Site Address: The Old Dairy Church Street Littlehampton BN17 5EL

Your Ref
LU/142/17/DOC
Our Ref
PLAN-018332
Date
23/05/2017

Proposal: Application for approval of matters reserved by condition imposed under LU/13/18/PL relating to conditions 5-details of obscure screening to balcony, 6-schedule of materials & finishes, 9-foul & surface water sewerage disposal, 10-surface water drainage, 11-SUDs system & 15-Construction Management Plan.
Site: The Old Dairy Church Street, Littlehampton, BN17 5EL
LU/142/17/DOC

DRAINAGE LAYOUT
SHEET 1 OF 2

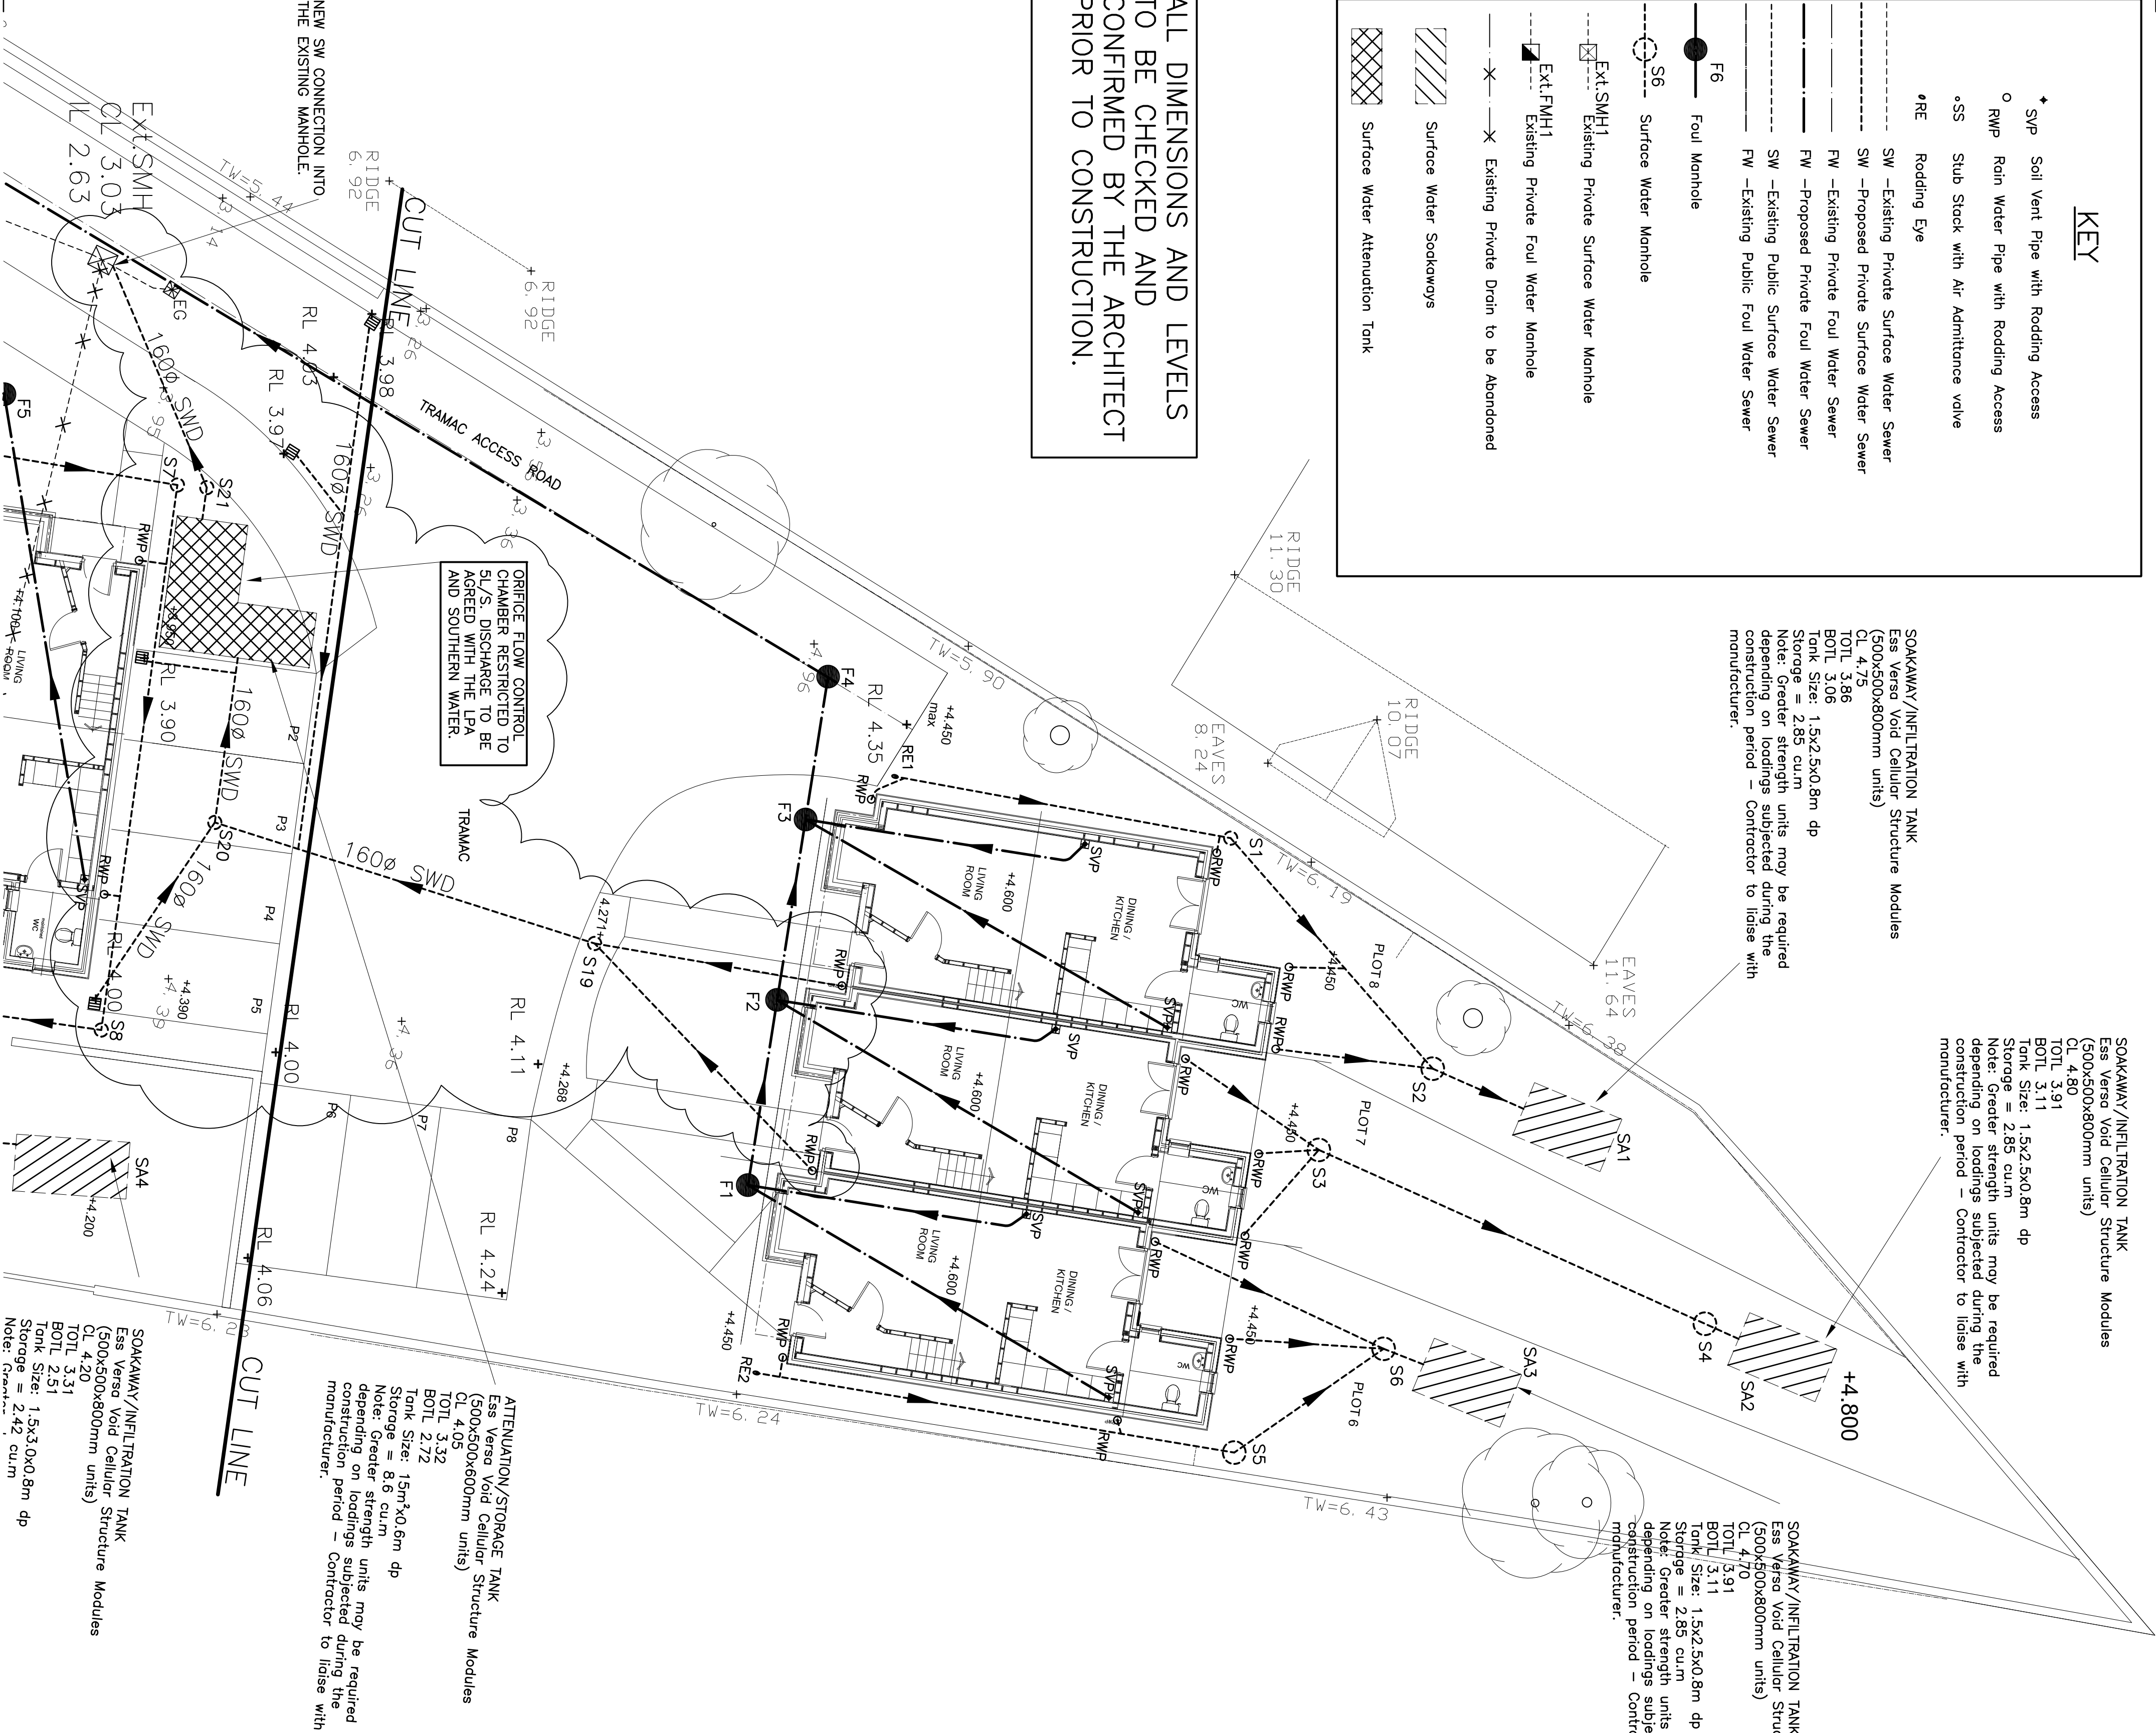
We regret Southern Water cannot recommend discharge of condition 9,10,11. Submitted drainage layout shows part of the site discharges surface water to Soakaway and part to public sewer.

Surface water flows from the entire development could be discharged to soakaway, if the (parking) layout is re-arranged to facilitate additional soakaways. Your Council's Building Control Officers or your own engineers should be asked to comment on the adequacy of soakaways to serve the development.

Please note that surface water disposal should comply with part H3 of Building Regulations.
